**RE: St MATTHEWS CATHOLIC COLLEGE, MUDGEE (SSD 9872)
CORNER BROADHEAD ROAD AND BRUCE ROAD, SPRING FLAT (MUDGEE)
POST RESPONSE TO SUBMISSIONS – REQUEST FOR ADDITIONAL INFORMATION**

I write on behalf of Trustees of the Roman Catholic Church for the Diocese of Bathurst in relation to the current SSD DA for the new St Matthews Catholic College – Secondary Campus at the corner of Broadhead Road and Bruce Road, Spring Flat (Mudgee) and provide a response to requests for further information arising from our Response to Submissions package of early October 2020.

DRAWING TITLE  
**INTERSECTION UPGRADE PLAN - SHEET 2**

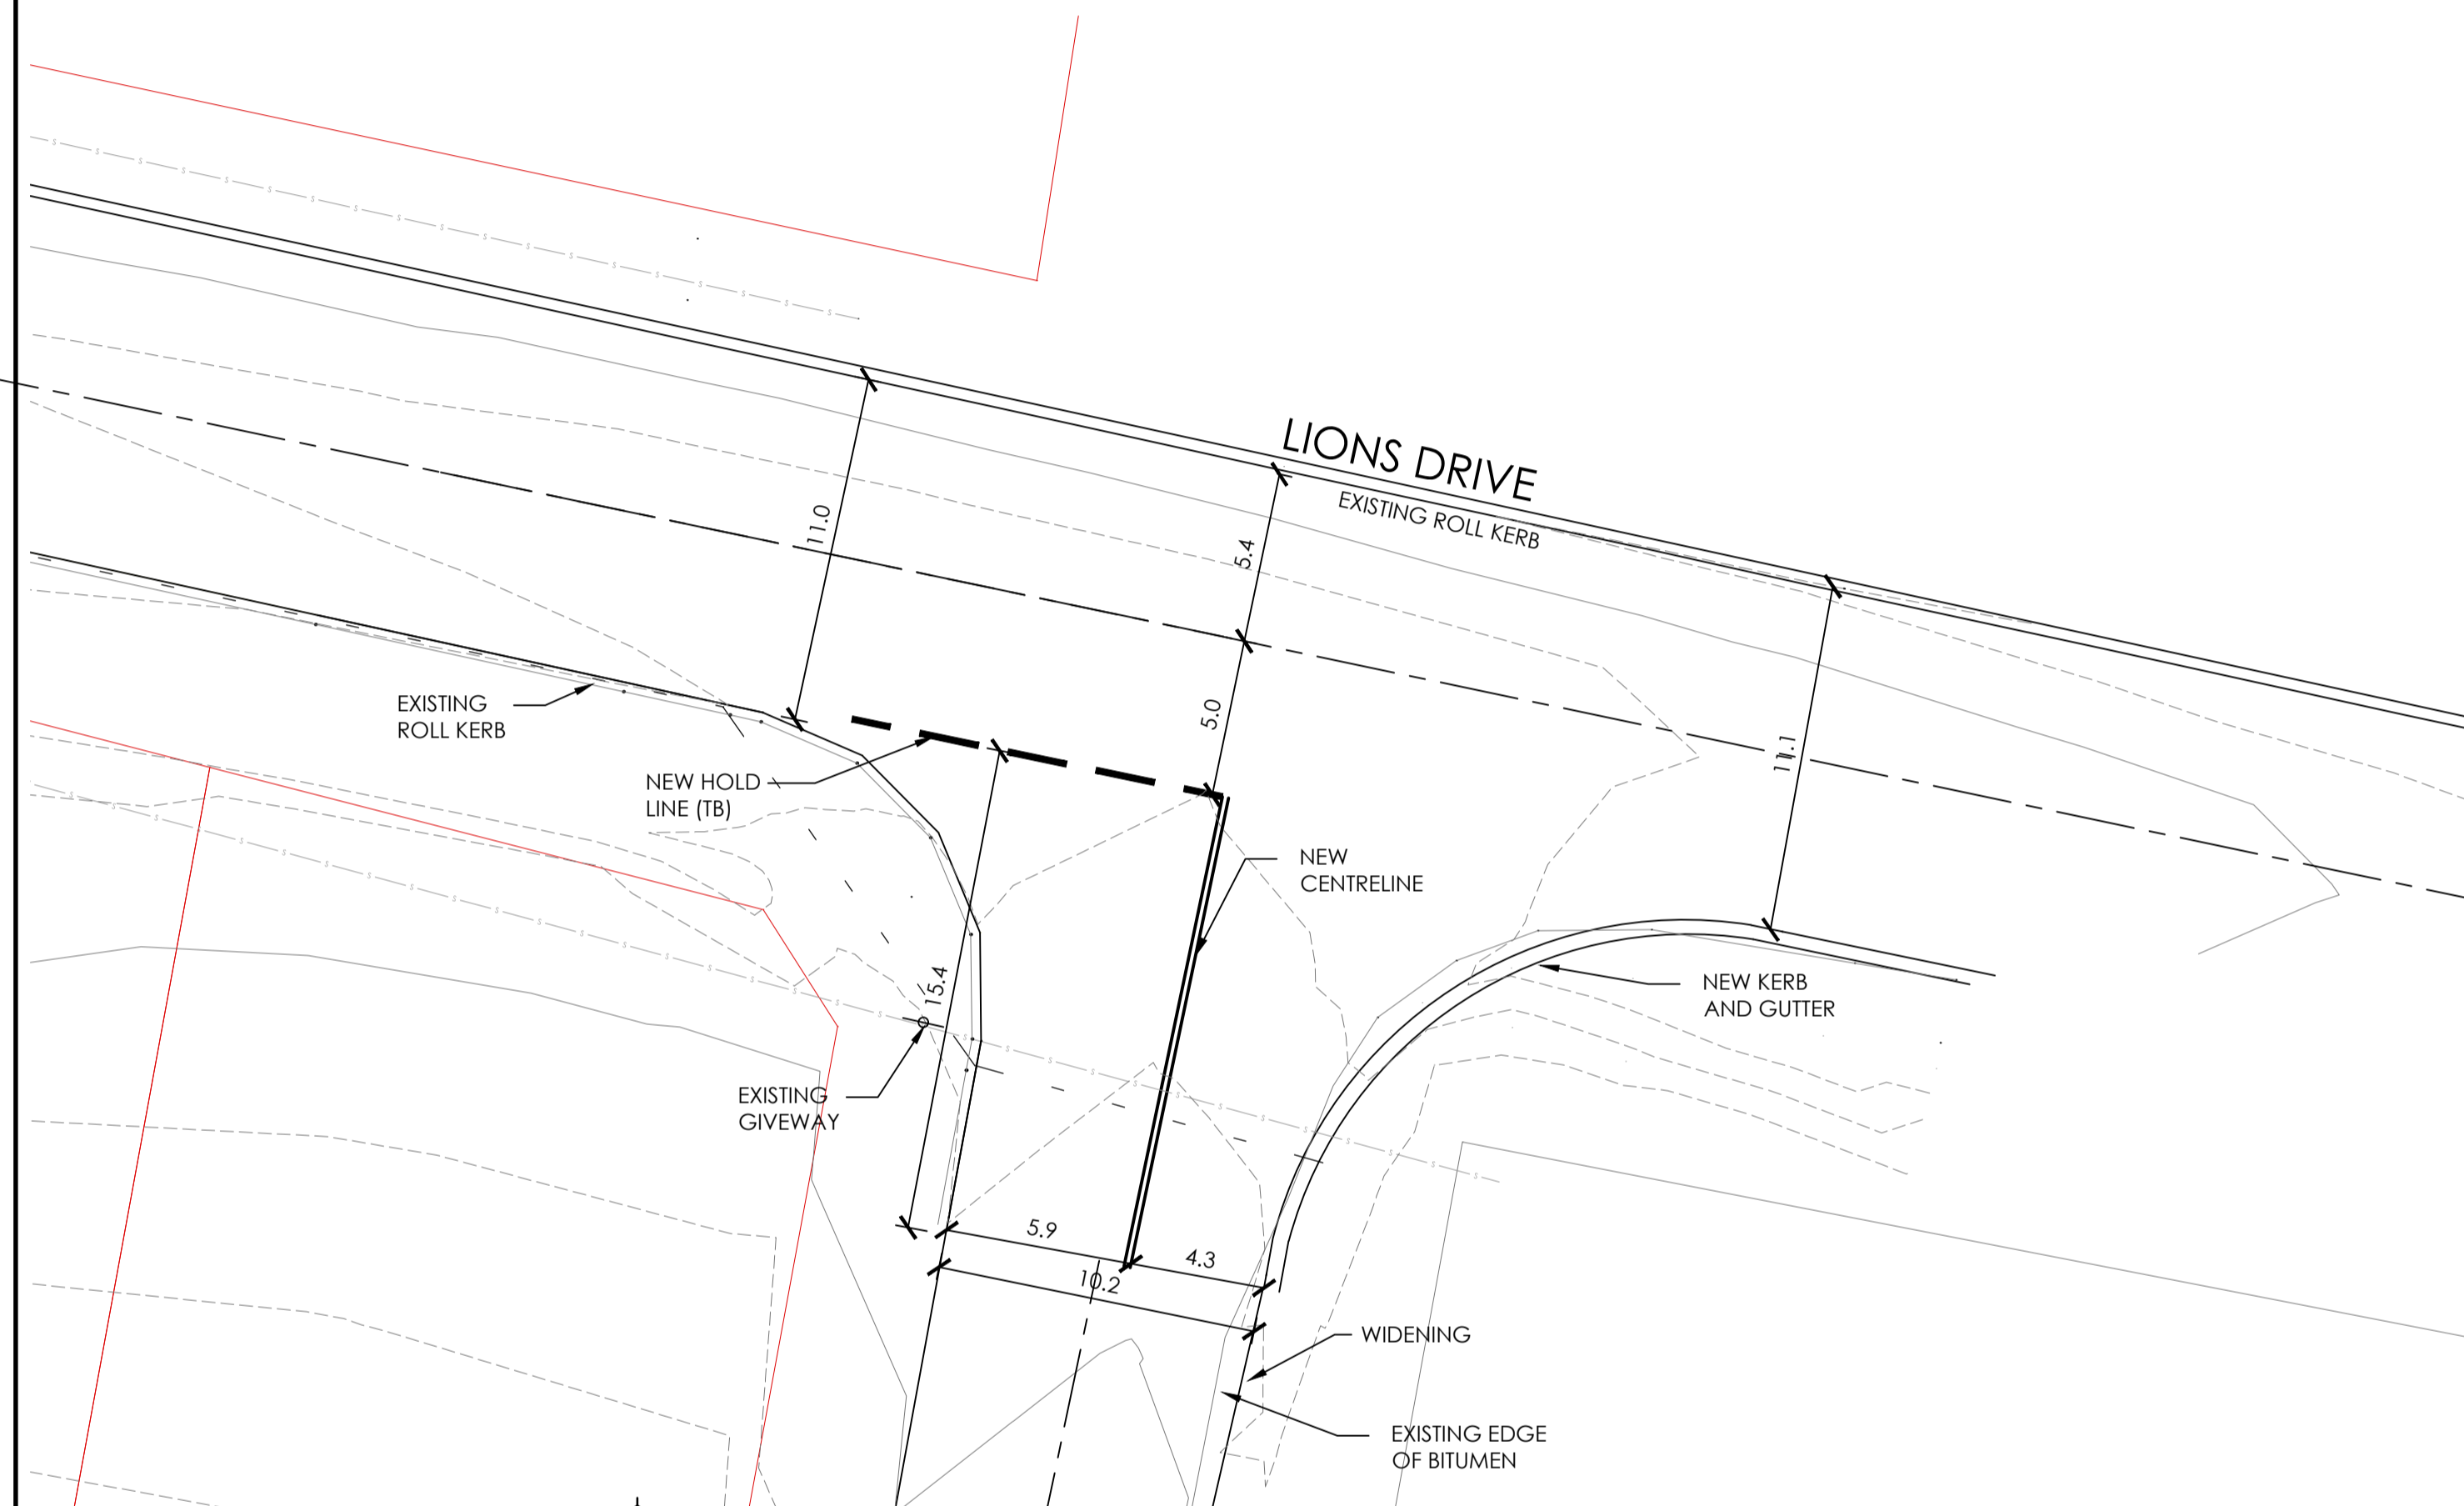
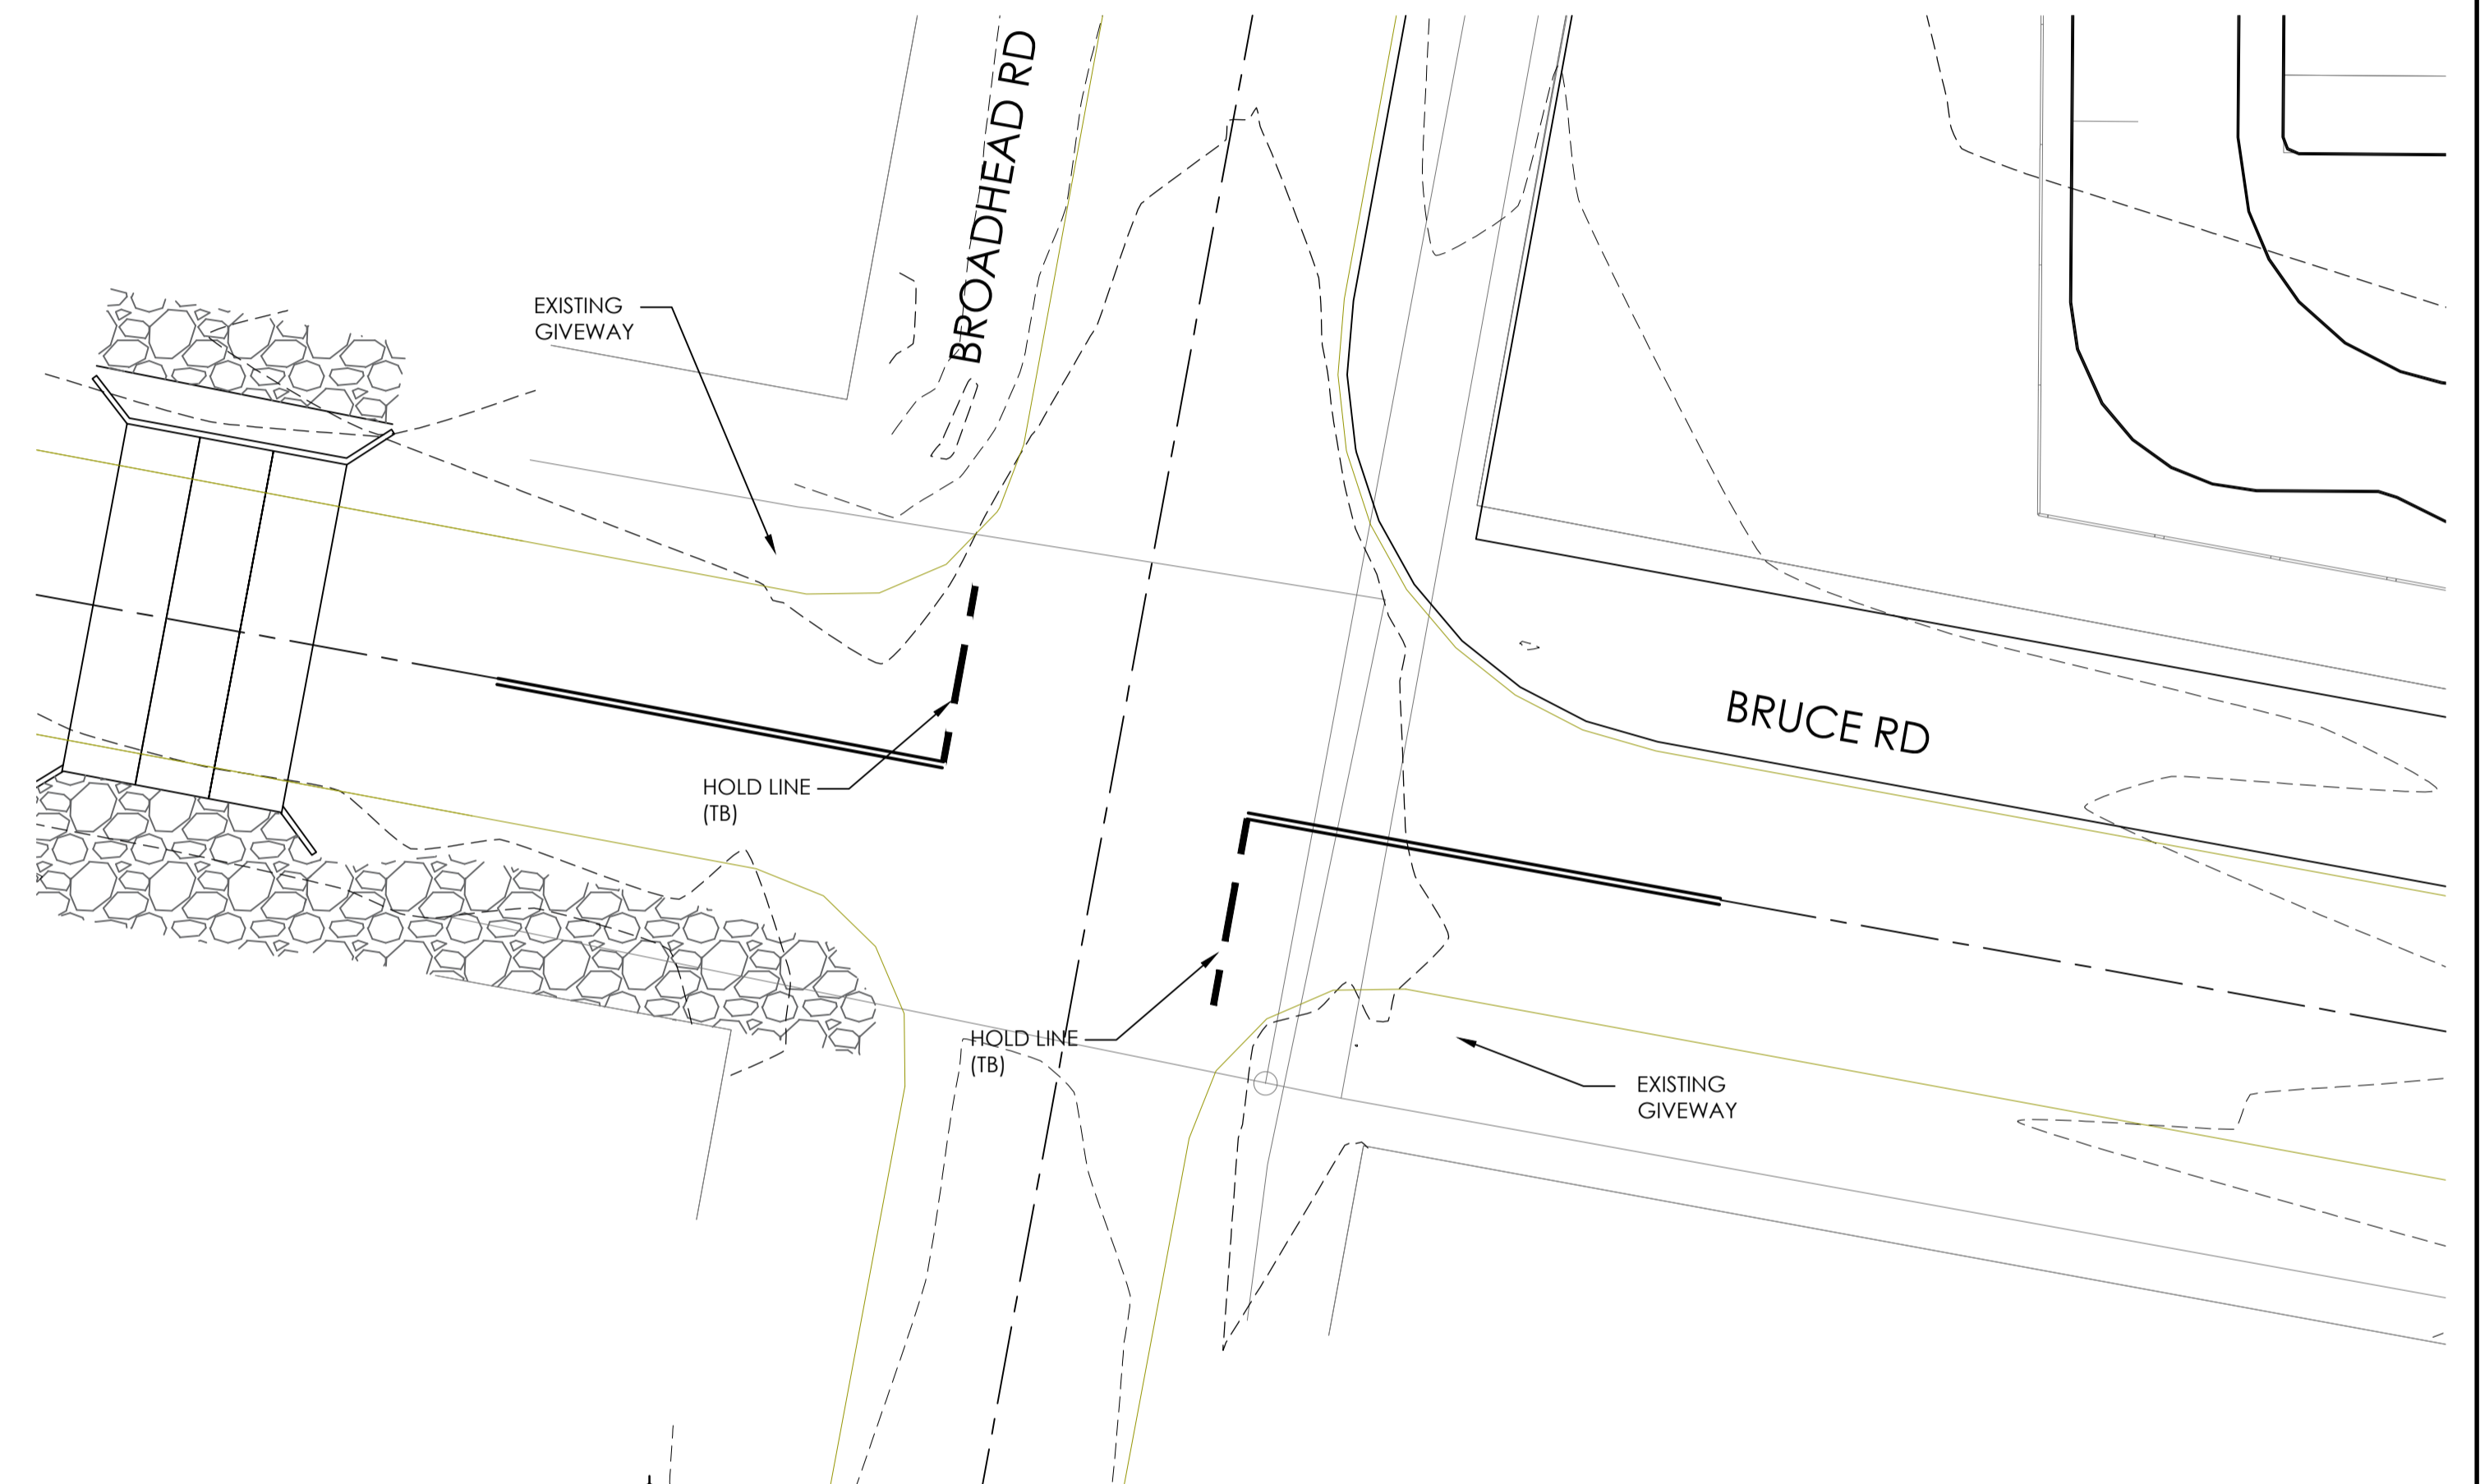
<p><u>Broadhead Road / Lions Drive</u> It is likely / possible that greater than 4% of vehicles exiting the School using Broadhead Road may wish to turn right at Lions Drive. Broadhead Road may require widening to provide for left and right turn lanes to avoid congestion and excessive queuing.</p>	<p>Broadhead Road / Lions Drive The Broadhead Road / Lions Drive intersection has been discussed extensively with Council and agreed would be upgraded to suit required swept paths for the school bus route along with suitable treatment methods for longevity. This latest request for widening and addition of lanes is not supported by the traffic modelling.</p>
<p><u>Robertson Street / Lions Drive</u> This is a T-intersection with Robertson Street as the through road. There is potential for a significant proportion of traffic (including existing traffic not associated with the school) exiting Lions Drive wishing to turn left to access Spring Road which provides alternative access to other areas of Mudgee South. This may also require some widening of Lions Drive to provide for left and right turn lanes. (Note: Existing pavement width might allow for turning lane definitions using line-marking only but further detailed survey and design would be required).</p>	<p>Note, also Council’s acceptance of the extent of Broadhead Road roadworks as set out immediately above in the first comment by Council on the submitted RtS – as quoted below:</p>
